Simon Truong - RE: RE: Student Accommodation S96 (SSD4949-2011) 157-163 Cleveland Street, Redfern

ADJOINING NORTHERN ELEVATION
CLEVELAND STREET
SCALE 1:200

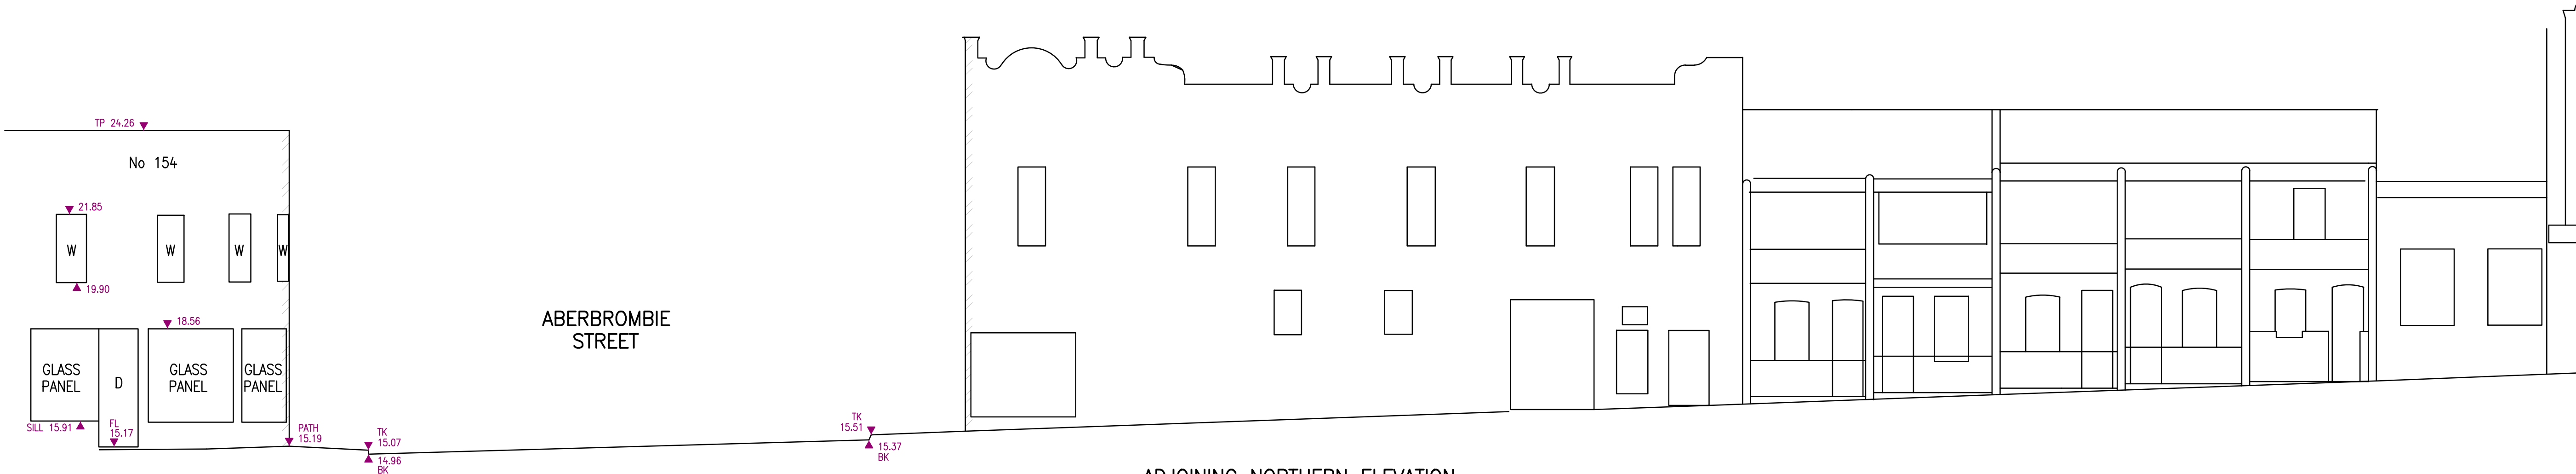
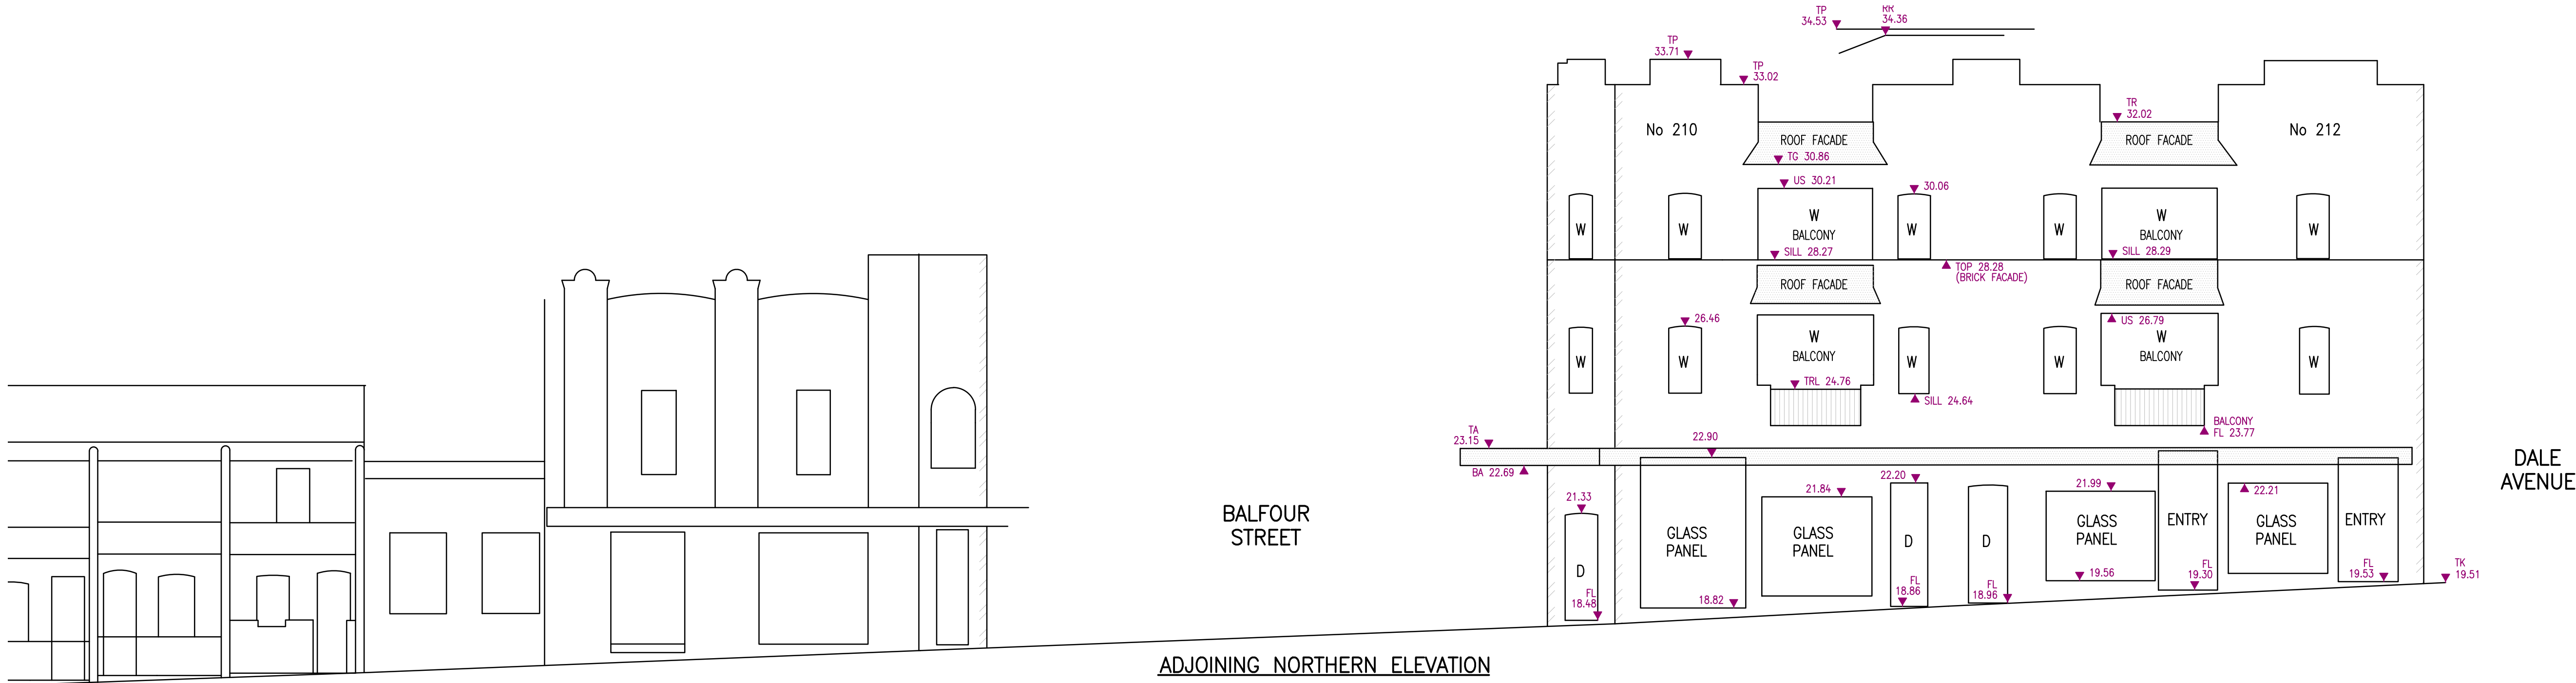
As discussed, can you please provide a response to Council's submission. I note that the copies of plans provided are not to scale and do not indicate the location of power poles and traffic lights.

In principle there is no objection to this modification, however, the information provided did not allow the City to make a full assessment. Based on the information provided it is not clear whether there are street trees, power poles, traffic lights etc. on this footpath that may require a certain setback of the new awning structure.

It includes surveys and marked up plans that demonstrate the awning achieves suitable separation distances from these.

Drawing no. A02.101
Revision 29

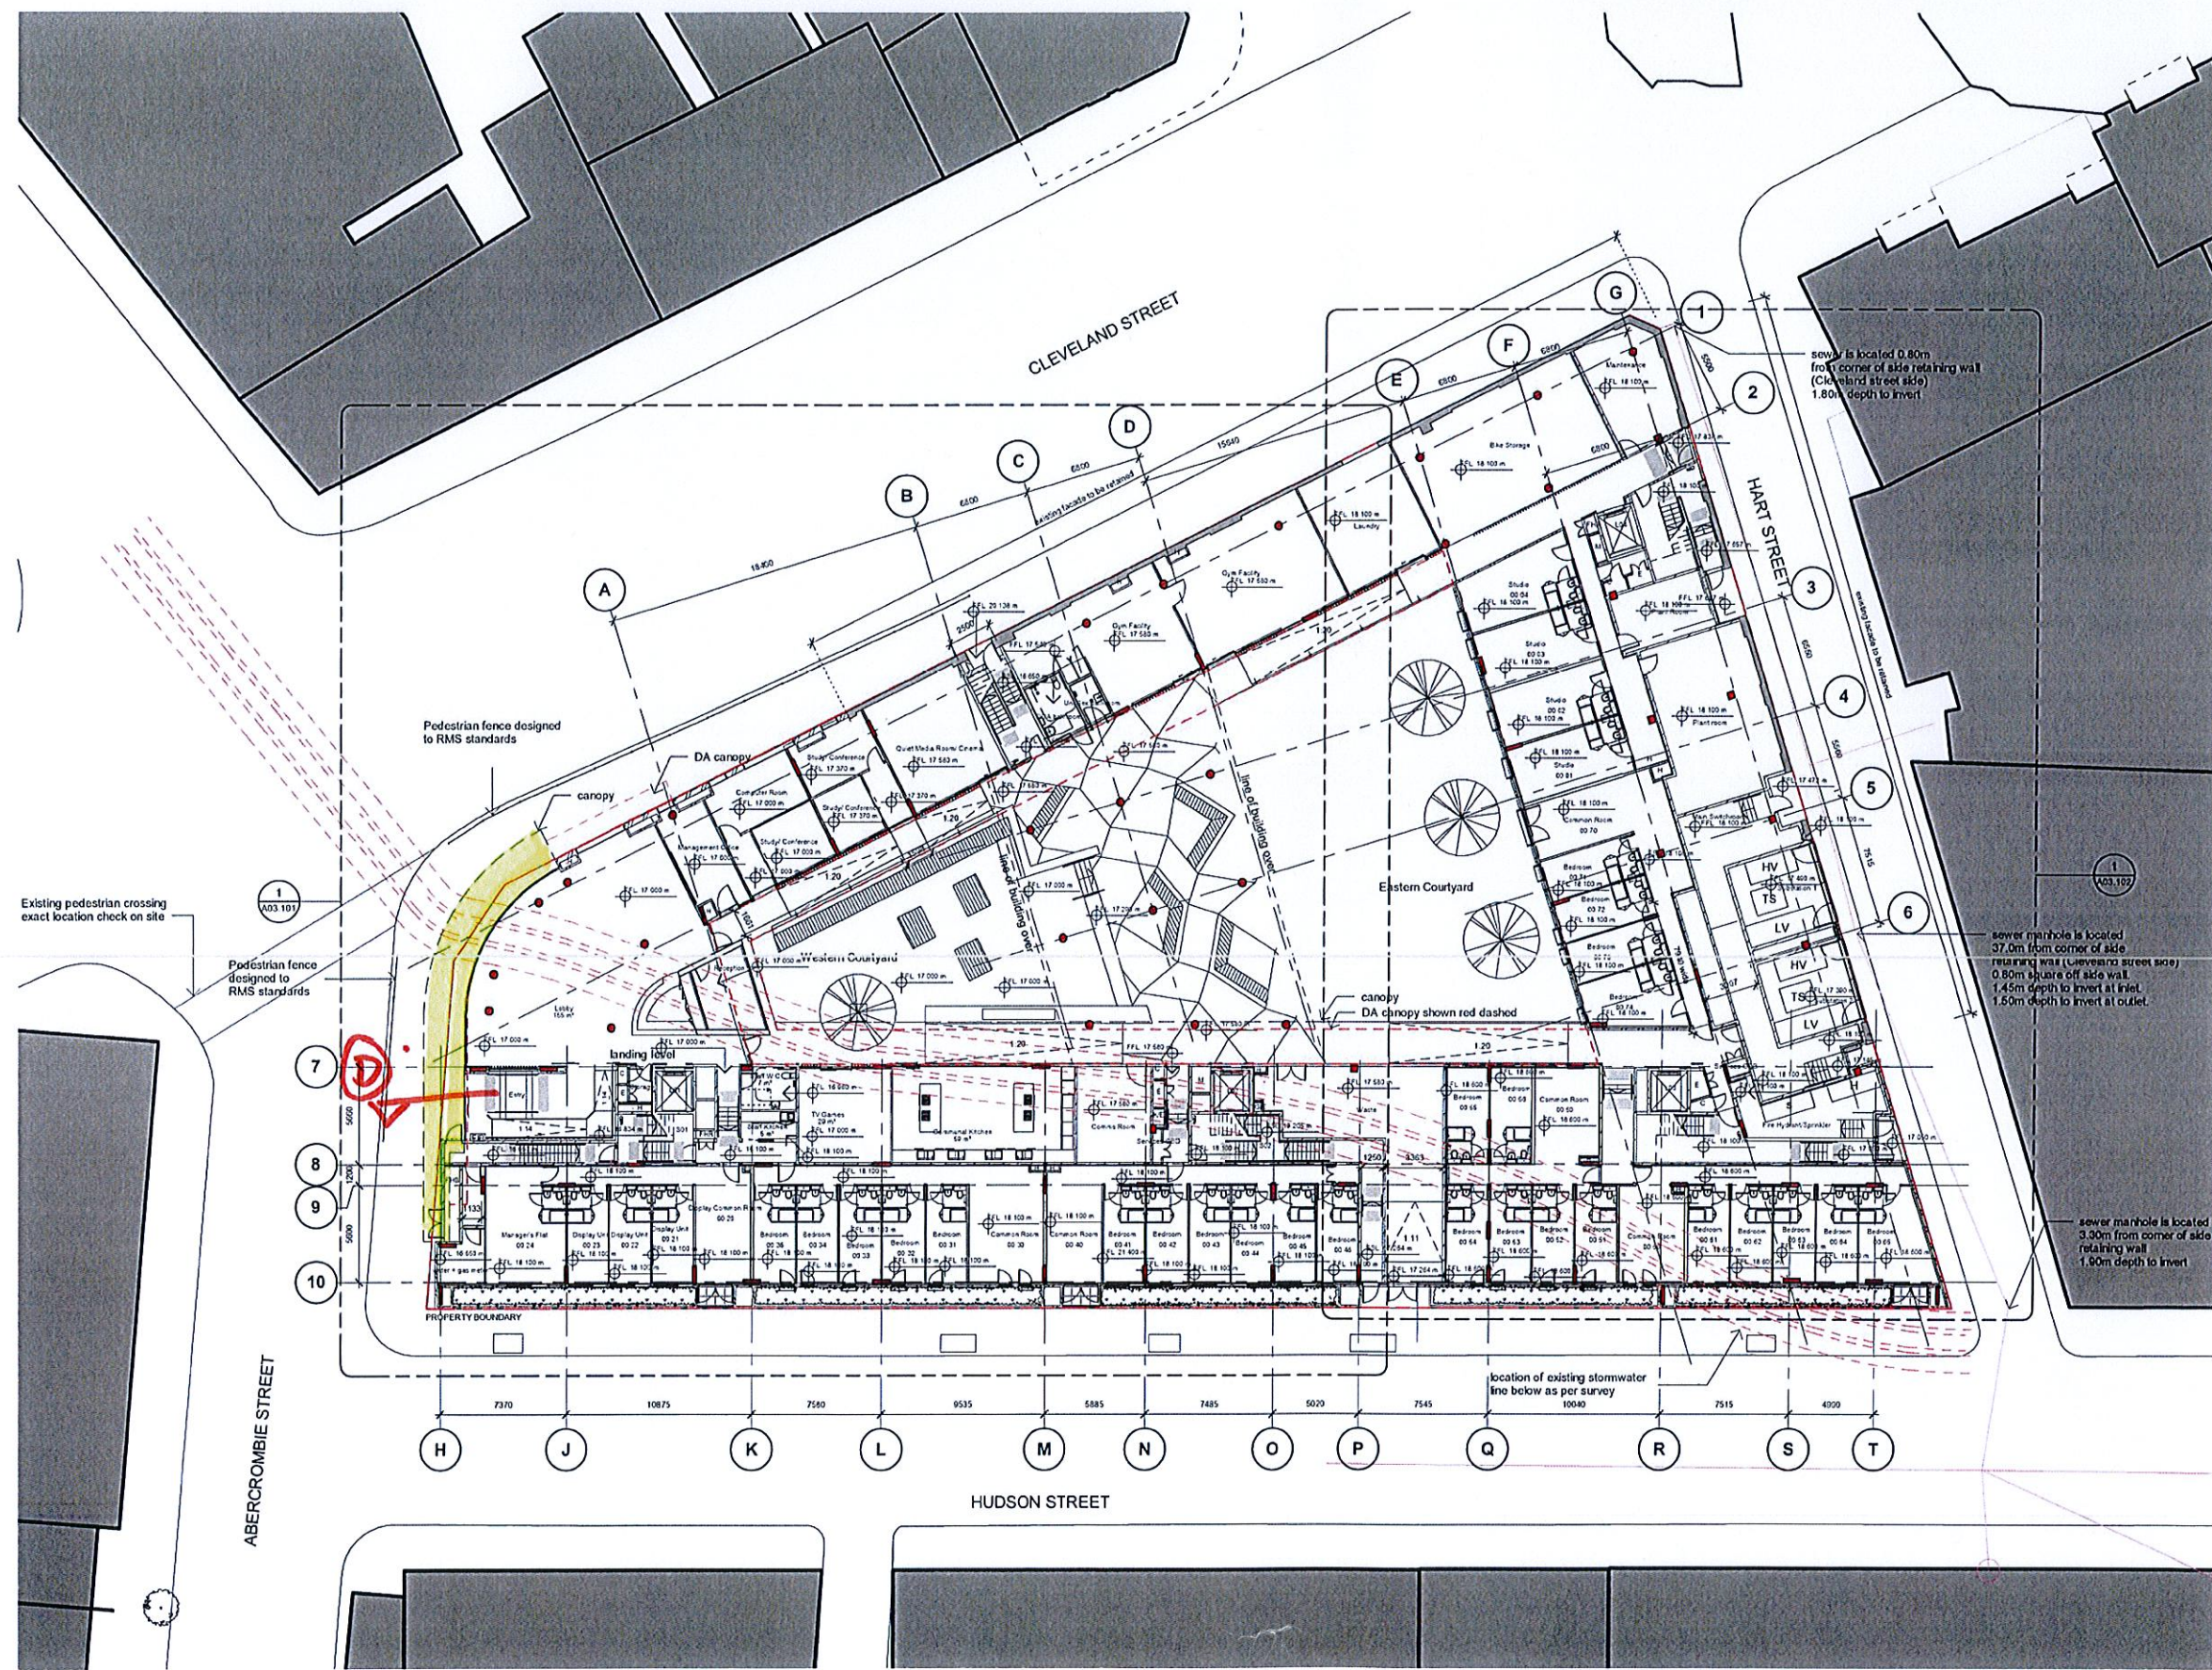
Can I ask that in any assessment that the Department give consideration to Section 3.2.4 of the Sydney DCP 2012 (link provided below). In particular, minimum setback requirements from the kerb for any new awnings.

Please find attached some additional information to show the proximity of the awning to surrounding structures.
